**Consultation Response from KC,
Highways Development Management**

2025/90707 Fenay Bridge Nurseries, Brewery Yard, Fenay Bridge, Huddersfield, HD8 0AR

Reserved matters application pursuant to outline permission 2020/91155 for demolition of existing buildings and erection of residential development (1 dwelling)

Date Responded: 1-5-2025.

DRAWING TITLE
 SITE LAYOUT - PROPOSED

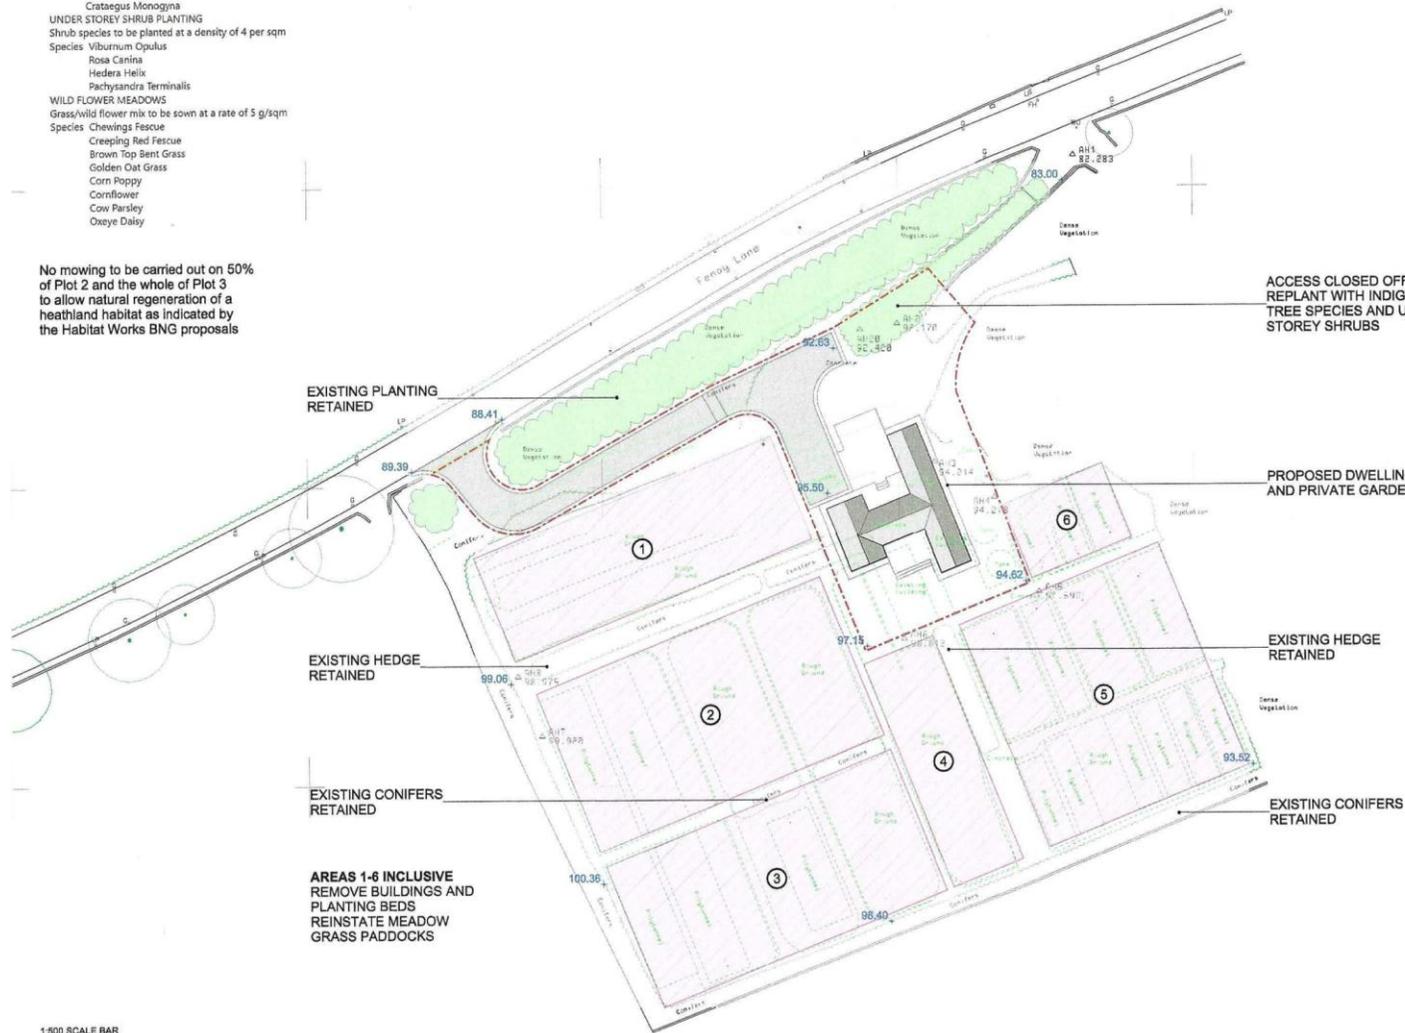
This proposal shows one large, detached dwelling including a substantial integral double garage with off-street parking to the front. Internal vehicle turning is also shown to be provided.

No information is shown regarding bin storage and collection.

Before development commences details of storage and access for collection of wastes from the premises shall be submitted to and approved in writing by the Local Planning Authority. The approved details shall be provided before first occupation and shall be so retained thereafter.
